Development Facilitation Team (DFT) – Review Comments

Project No: PR-2022-007103 Date: 07/10/2024 Agenda Item: #1 Zone Atlas Page: M-14

Request: Final EPC sign-off for Love's Sunport development, Loves Travel Center

Application For: SI-2024-00922 – EPC FINAL SIGN-OFF

CAUTION

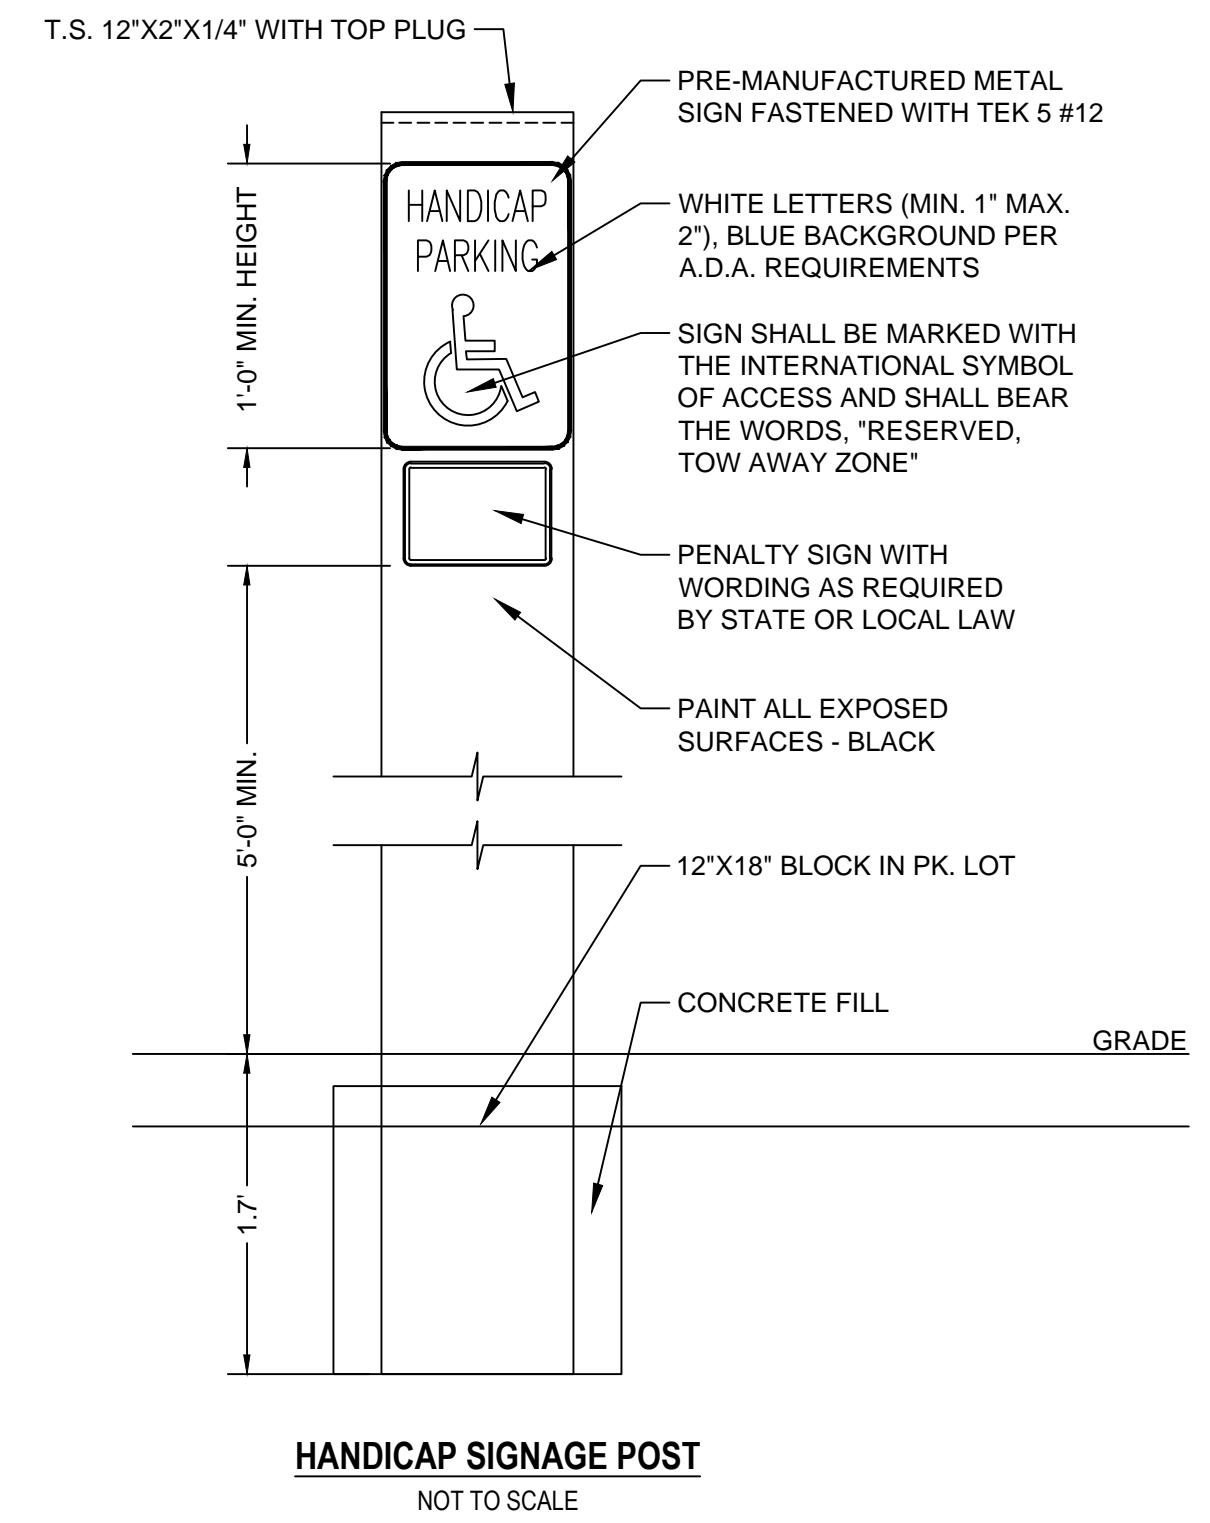
6. Light poles are limited in height to 30 feet in the (non-residential zone districts (NR-LM), as per IDO 5-8(D)(3), Table 5-8-1. Please correct note on sheet SP-2, Travel Center Site Plan, and related detail plans on sheet DET-1.

SHEET DET-1: See excerpt from details shown on next page, indicating height of 40 feet.

- Confirm all Use Specific Standards are being met. Clarify how each is demonstrated within the submittal.
Confirmed
- Clarify lighting height. Plan elevation measurement is not shown from finished grade.
See light pole detail on DET-1 plan sheet. 30' max height shown from finish grade

light pole callout revised to reflect 30' max height on plan and detail sheet DET-1

light pole callout revised to reflect 30' max height on plan and detail sheet DET-1

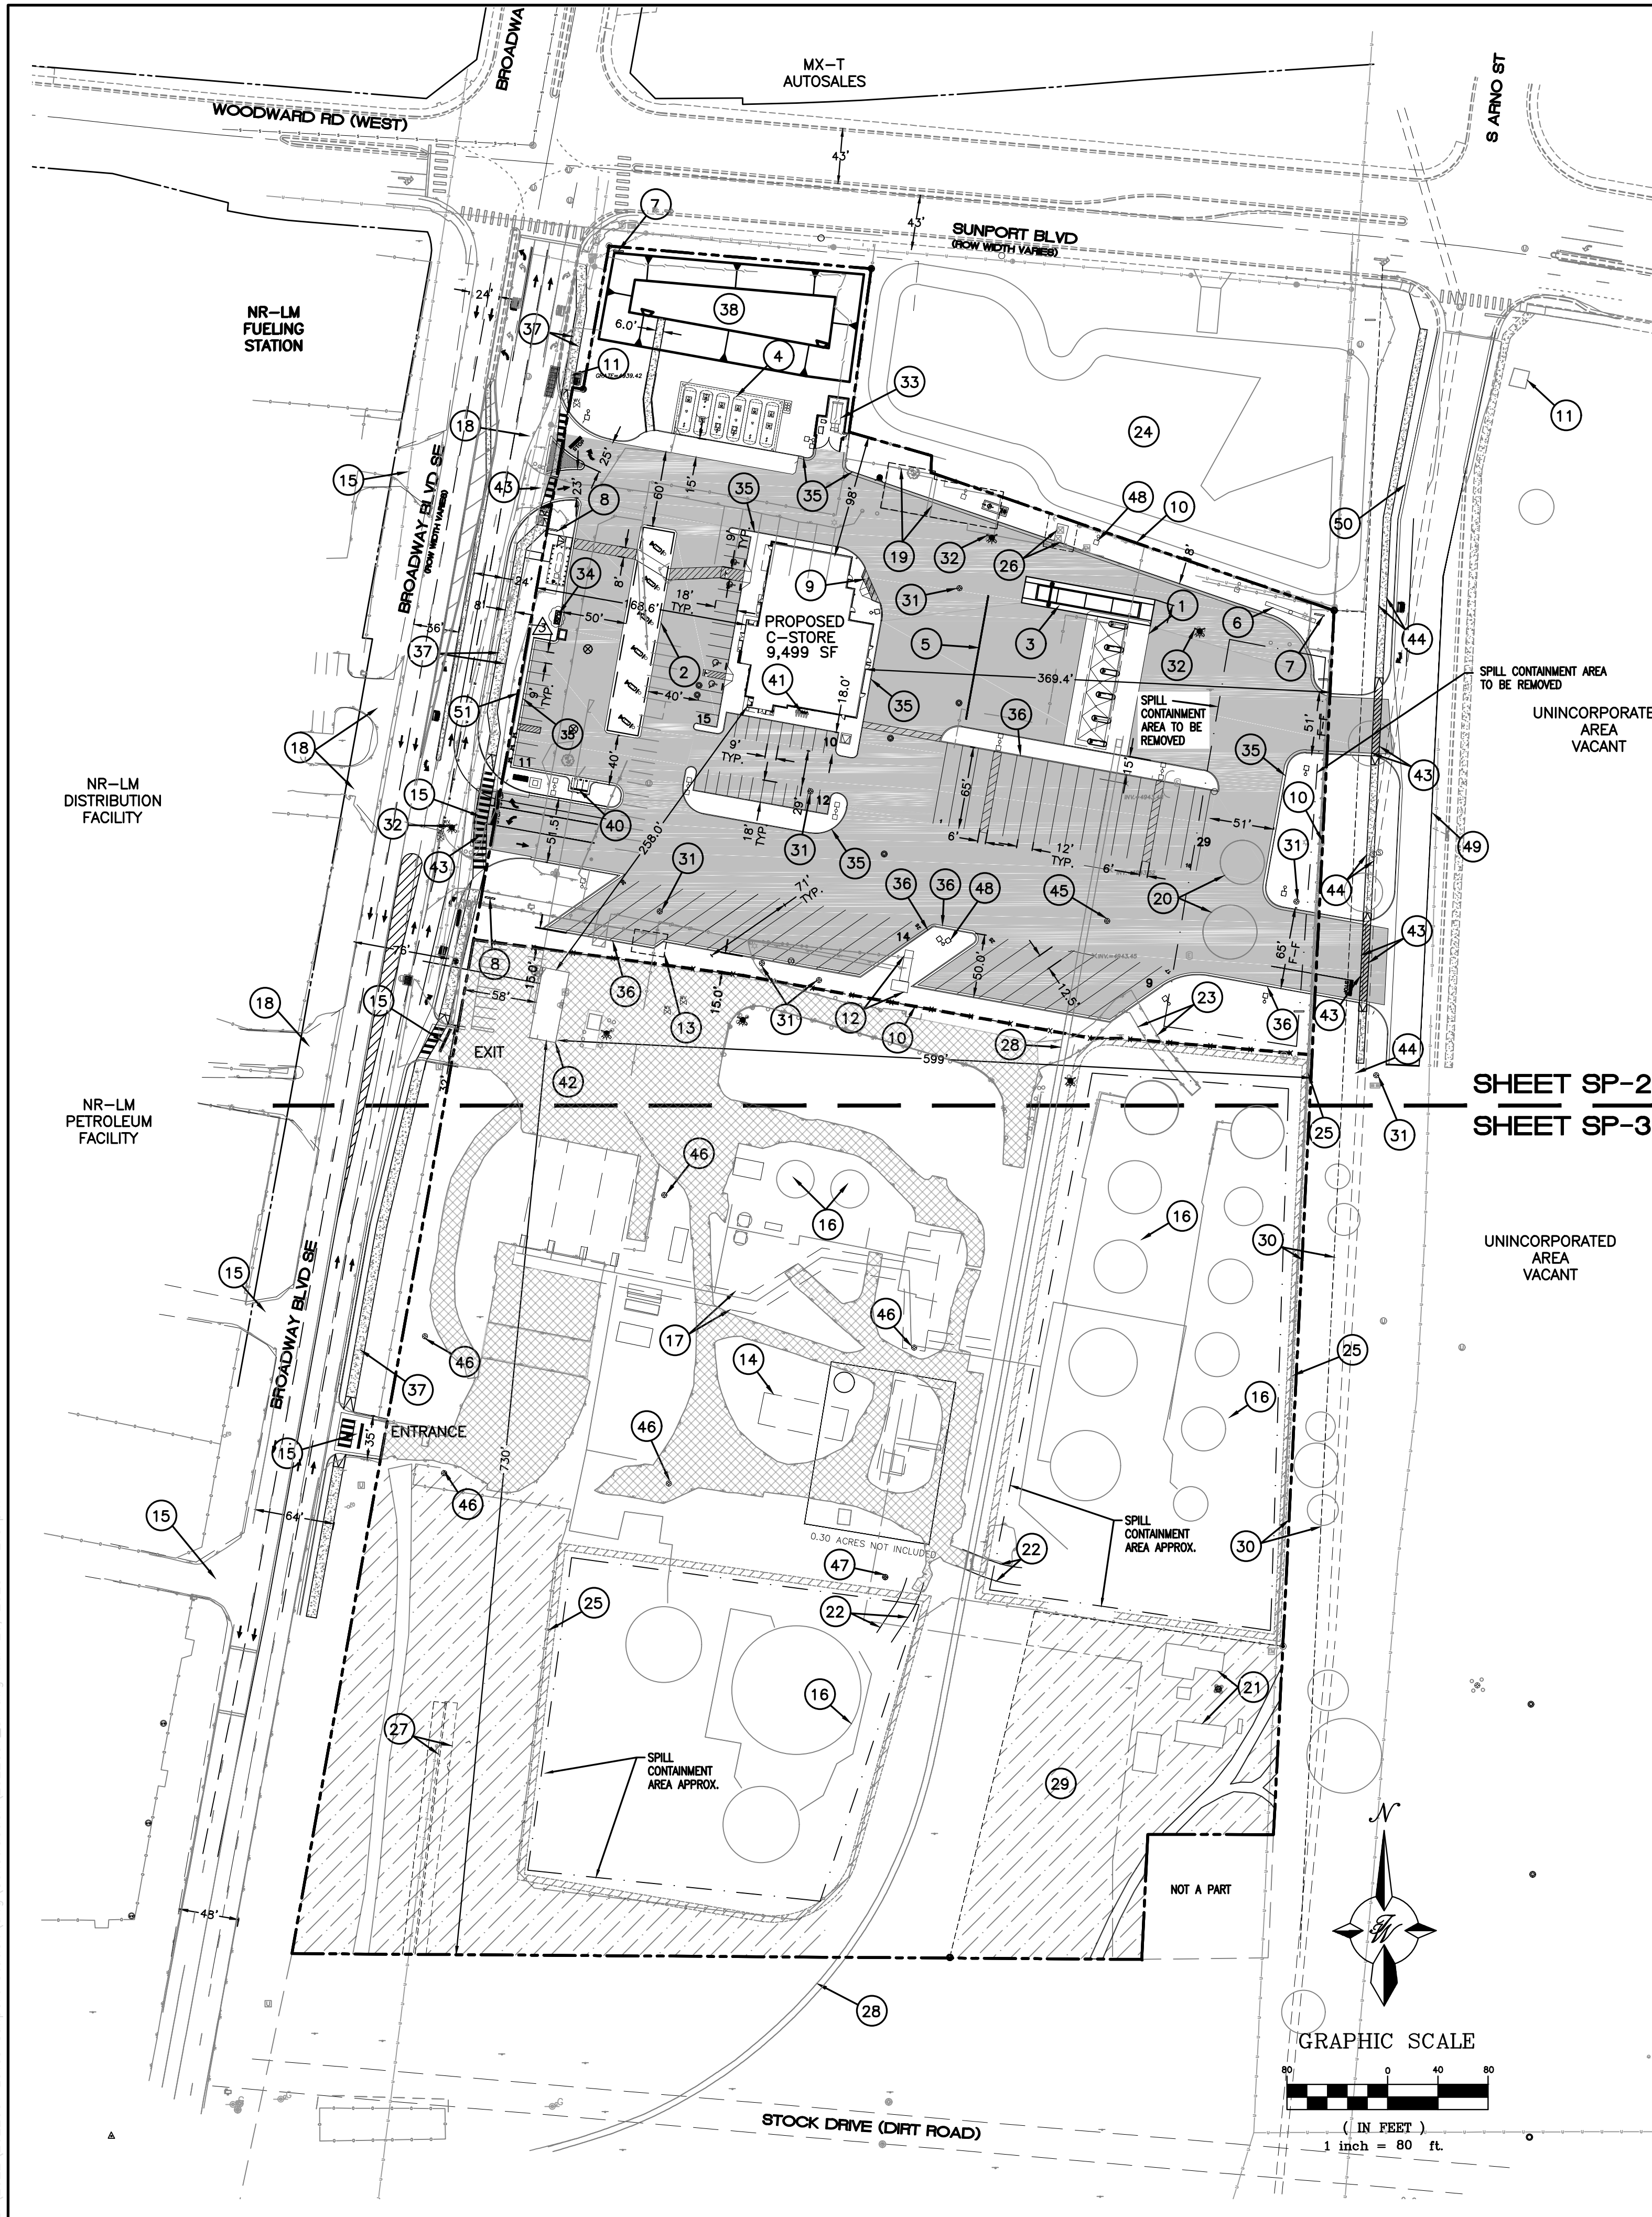
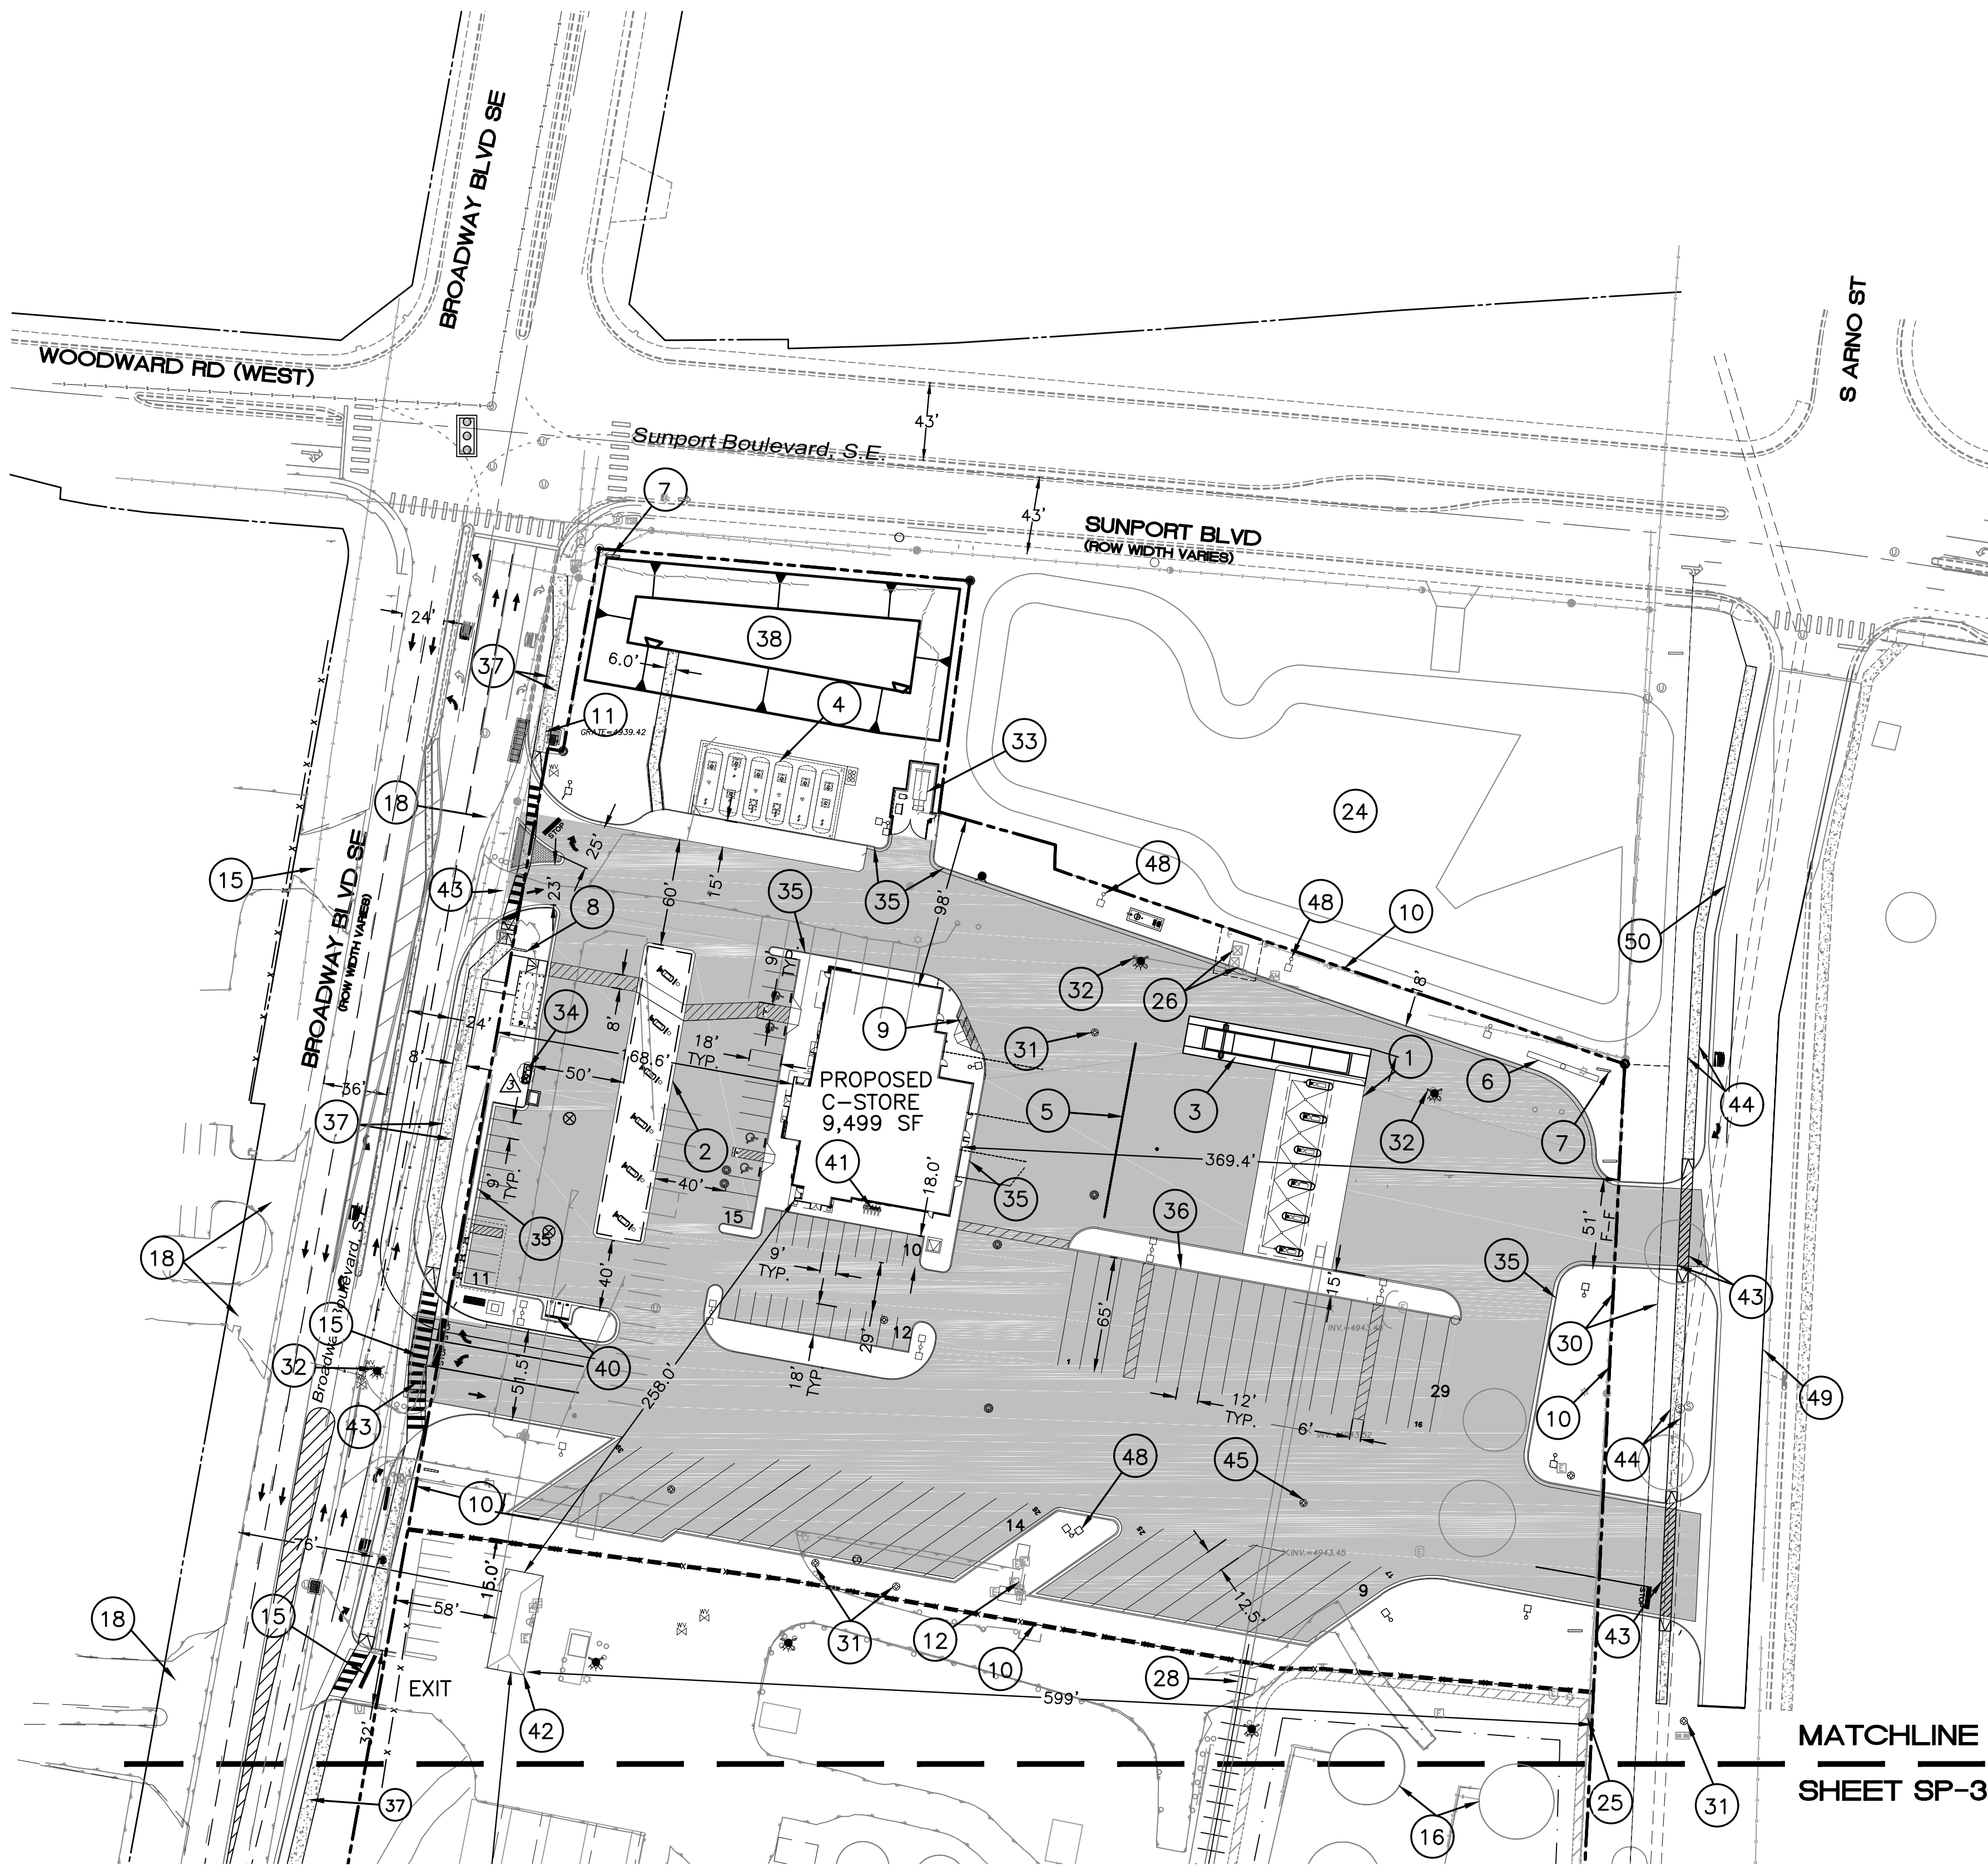
4. Parking Calculations on Sheet SP-2: Parking appears sufficient, but calculations shown are inaccurate. The calculations are to be based on Gross Floor Area of each use...and if the same building has multiple uses, it is generally either split between the specific GFA for each use, or just based off of the highest related GFA for the combined uses.

- Light Vehicle fueling (LVF) = 4 spaces/1000 GFA
- General Retail = 3.5 spaces/1000 GFA
- Heavy Vehicle fueling (HVF) = 1 space/1000 GFA
- Restaurant = 5.6 spaces/1000 GFA (it is shown as 8/1000)

- Show GFA for Restaurant, and parking calculations for Restaurant
- Show GFA for Light Vehicle fueling and parking calculations for LVF
- If Light Vehicle fueling, Heavy Vehicle fueling, and General Retail are all utilizing the same space – parking will be covered in the LVF area calculations of 4 spaces/1000.

1 – AREA LIGHT SHALL BE FULLY SHIELDED AND MAXIMUM
35 FT HEIGHT

parking calculations revised per suggestions
